Environmental Health Consultation Response	Officer	Michaela Gleave
--	---------	-----------------

Detail: Proposed change of use from Class E to B2 General Industrial.

Address:	TMG Sports Vehicles Building D (Units 16 to 21) Mitton Road Business Park Mitton Road Whalley BB7 9YE			 Ribble Valley Borough Council www.ribblevalley.gov.uk
Application Ref:	03/2021/0488	Case Officer:	John Macholc	
Response Ref:	46327/Y01	Issue Date:	22 nd June 2021

## Proposed parking plan TMG -

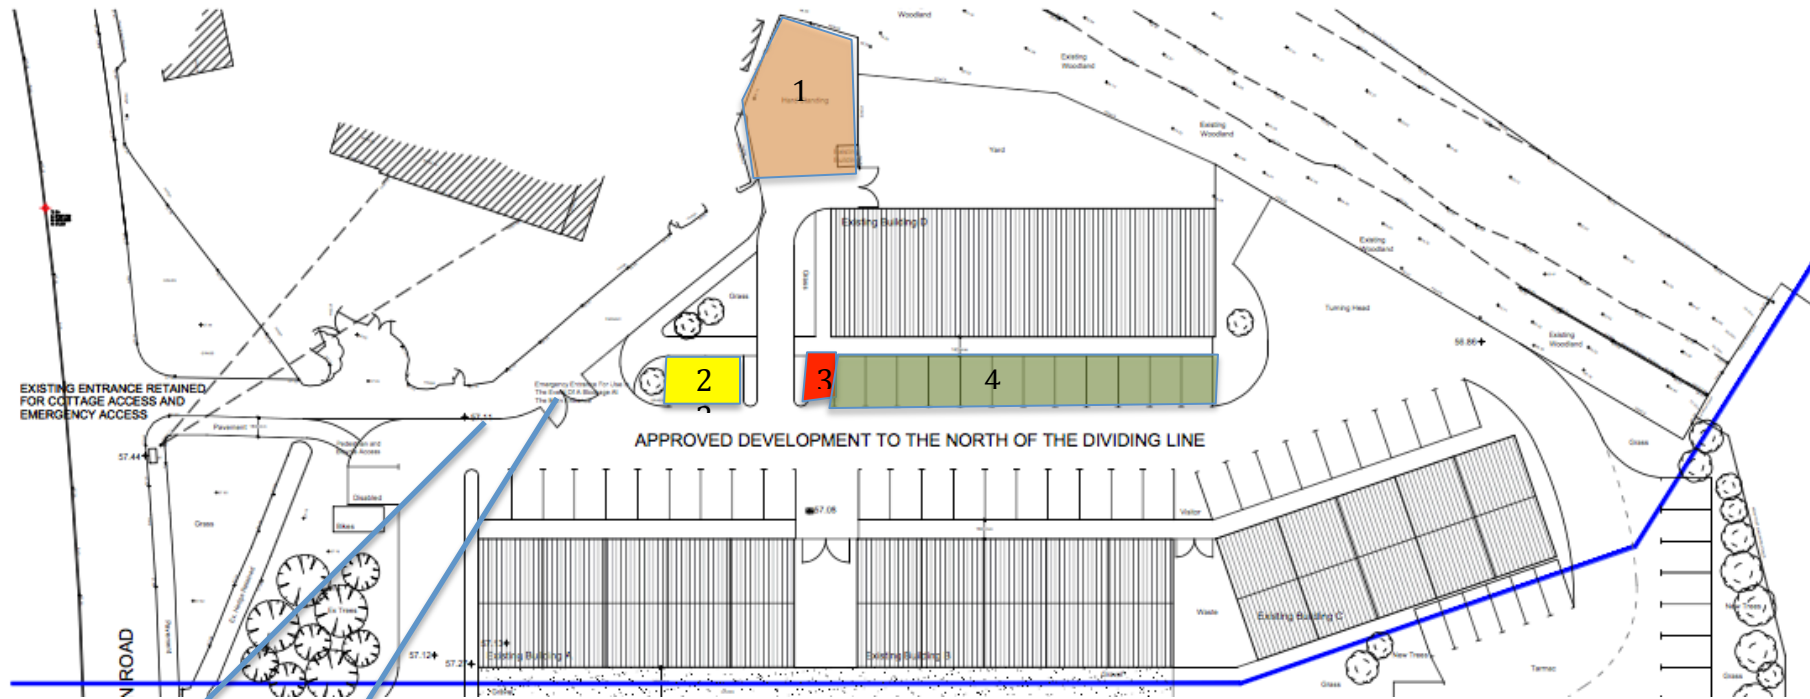
2.2	Details for the design and provision of an adequate and continuous acoustic barrier at the boundary with 1 The Cottages Mitton Road Whalley (as suggested on the proposed parking plan submitted with the planning application) should be submitted for approval to the local planning authority.
